**Santa Sophia Catholic College, Red Gables Road, Box Hill North (SSD 9772)  
Notice of Exhibition**

## **Attachment A: Comments on the proposed Santa Sophia Catholic College (SSD 9772)**

Figure 4 – Secondary Pickup Dropoff

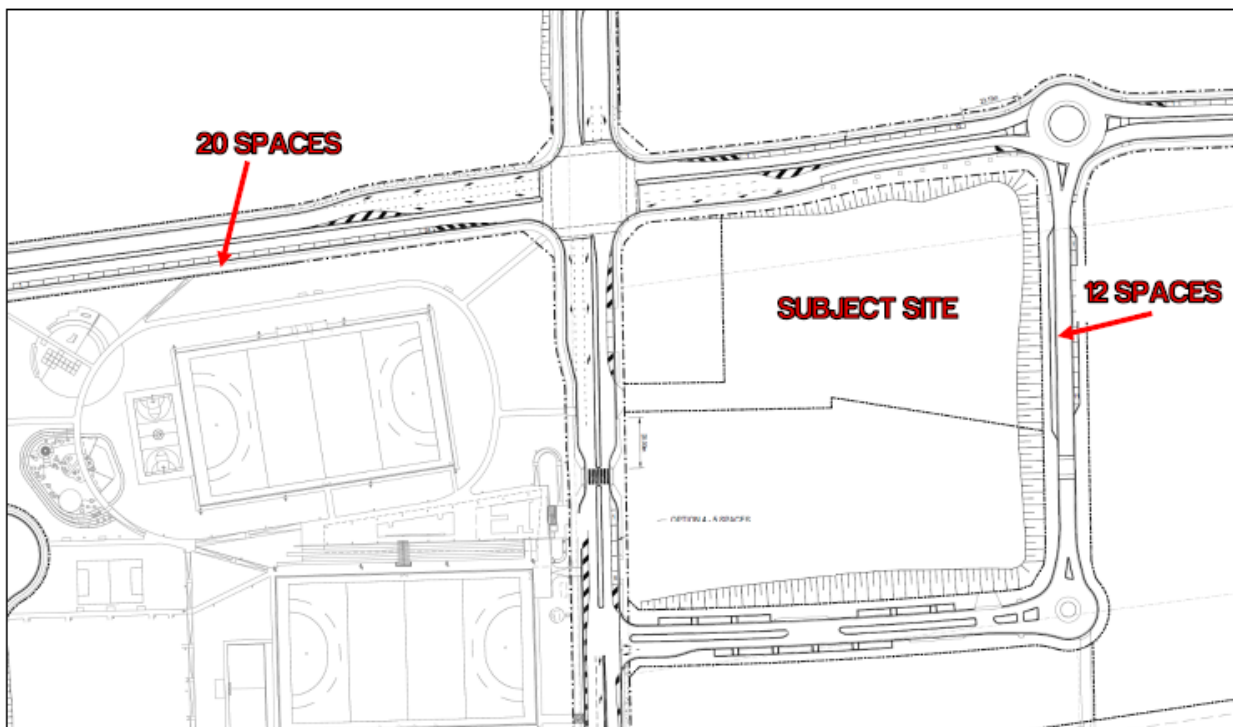
Section 8.4 of the TAIA compares the pick-up and drop-off provisions at SMCC and states that 24 spaces would be required to accommodate the demands generated by the entire school population. The TAIA notes that the 15 pick-up/drop-off spaces at the SMCC are insufficient as a queue of some 80m (approx. 27 car lengths) beyond the school boundaries was observed. A total of 12 on-street pick-up/drop-off spaces are proposed to accommodate the initial stages of the school (not at the 1,860 student capacity) with the intention to expand the provision should future demand require it.

There is the risk, as the precinct develops, that there could be limited scope to expand the on-

street pick-up/drop-off facilities due to competing priorities or road space constraints. This could result in on-street queueing and subsequently unsafe pick-up/drop-off behaviours in the future, due to the current provisions being overcapacity. Therefore, appropriate facilities should be reserved for future use, when/if required.

An adequate pick-up/drop-off facility should be provided that accommodates the likely demand generated by the school. Road space, beyond the initial requirements, should be preserved and released for future use as demand increases over time. This allocation would then be reviewed as the school approaches the approved capacity.
